RE: C121 – Units 3-7 Stonefield Close, Ruislip – Technical Notes for Building Movement

Further to our recent Section 73 application we would like to comment on the following:

Title
Proposed Site Plan

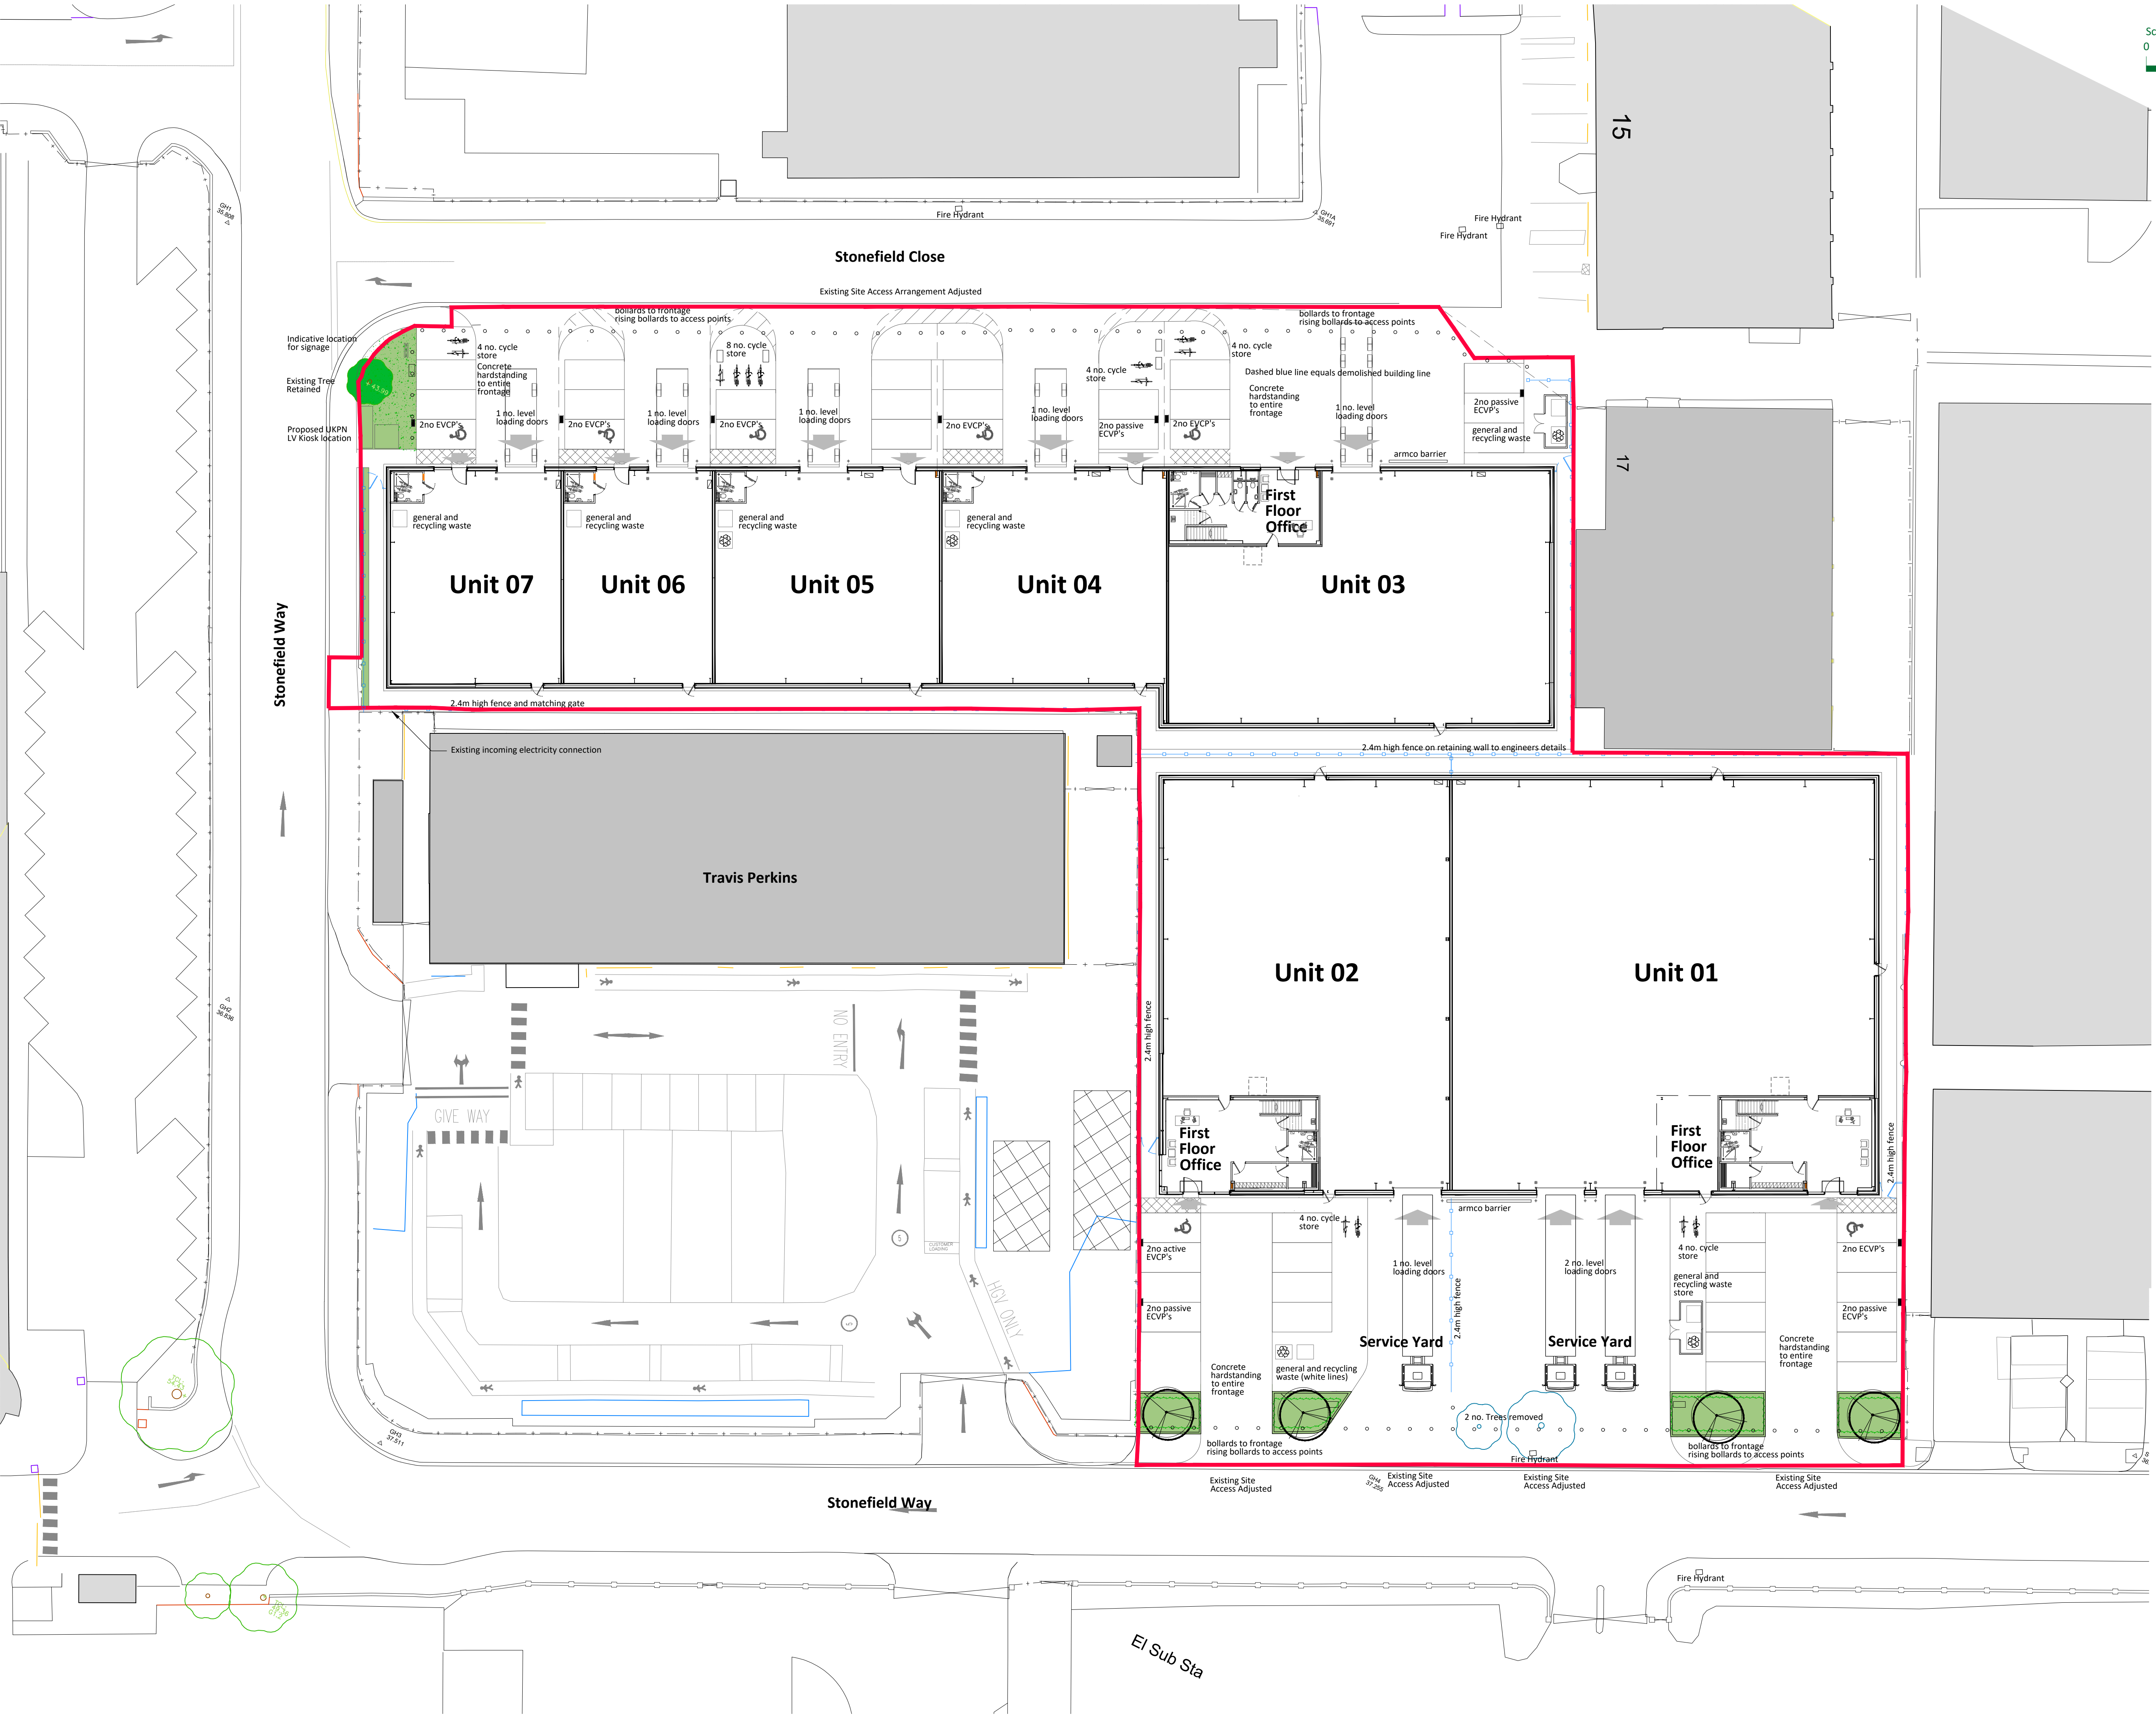
Drainage for the scheme will not be affected in regard to capacity and all drainage sizes will remain as shown at planning drawings. The inspection chamber sizes will remain as currently drawn and will not need to be relocated. The only change is that some of the storm runs from the back of the building will get shorter by 300mm in length and the foul connections within the building will also get shorter by 300mm in length.

Hardstanding type and layout will remain as drawn from the planning stages with the service yard reducing in size by 300mm. The surface finishes will not change as per the planning drawings and will remain as reinforced concrete yard and reinforced concrete footpaths. Car spaces will remain as shown with no reduction in numbers and access to and from site will remain as shown.

On a whole the building move will have a negligible effect on any elements of the construction works as denoted above and will only improve the rear access behind units 3-7 for future maintenance and upkeep of the building envelope.
